**Talavera Road Data Centre Campus Expansion (SSD-24299707)
Additional Matters for Submissions Report**

ATTACHMENT 1

Based upon the Department's review of the information of the EIS, the Department considers further information is required to clarify matters and addresses inconsistencies within the documentation. In this regard the following information is required to be provided:

2 **GFA PLAN - LEVEL 01**
1 : 500

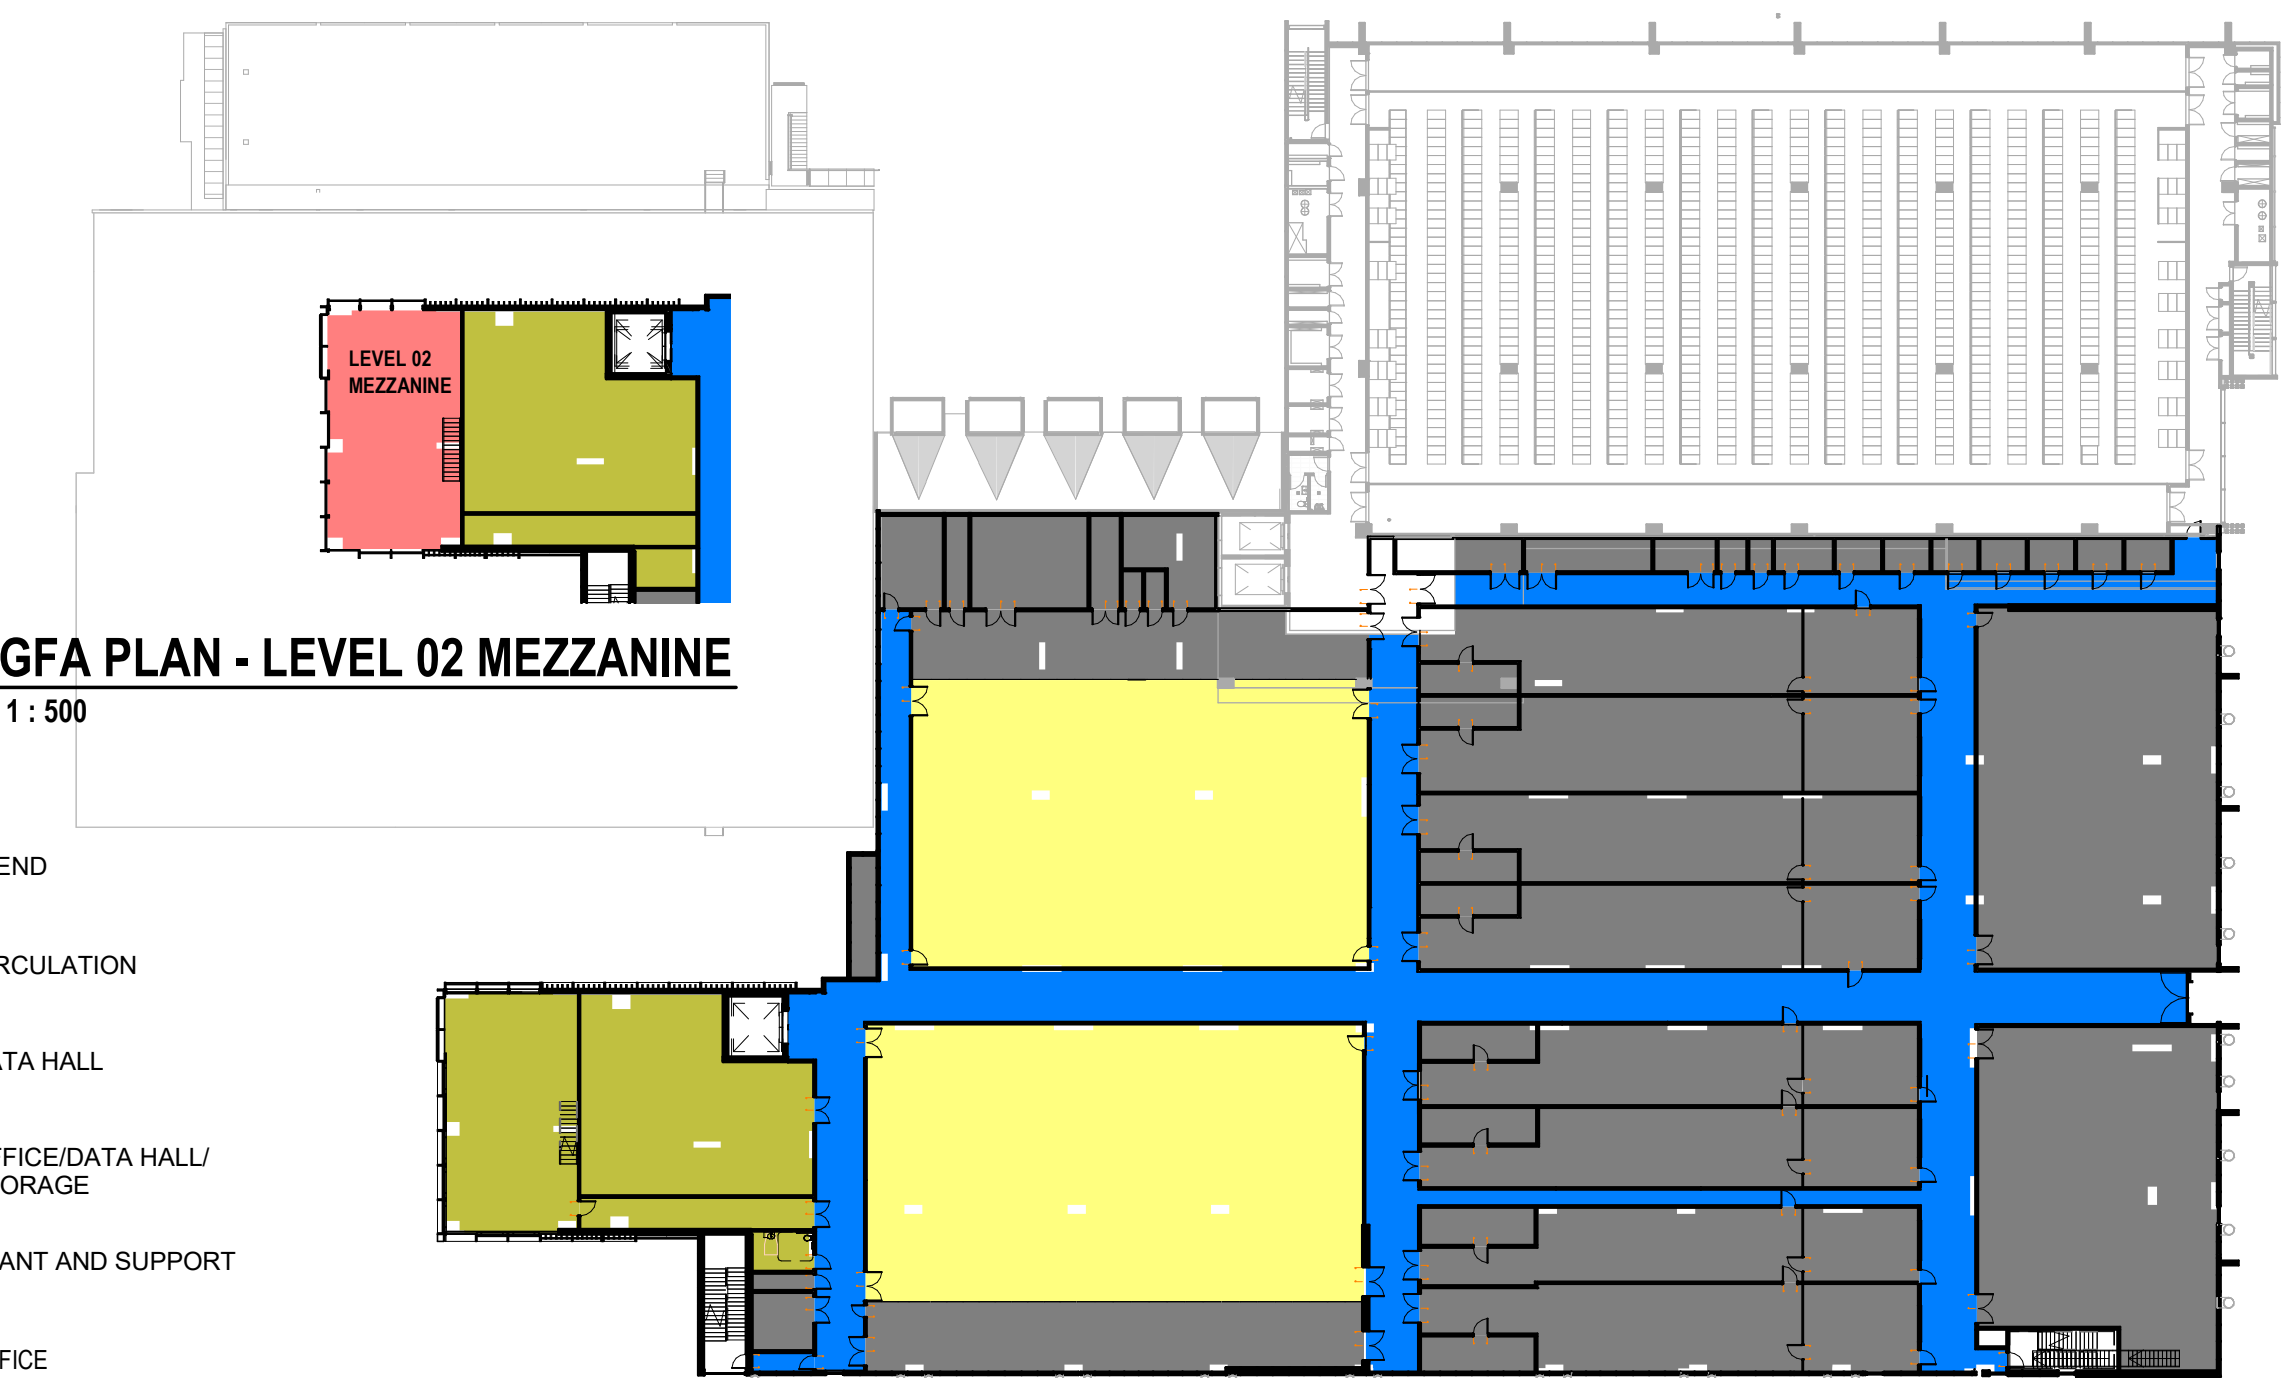
30. The Department notes the GFA figures referred to in the EIS differ slightly from those figures referenced in the architectural plans. Please clarify accordingly.
31. The Department notes the number of proposed construction jobs (1,200 jobs) is significantly higher than comparable projects in the surrounding area. The Submissions Report should clarify the assumptions which have informed this number.
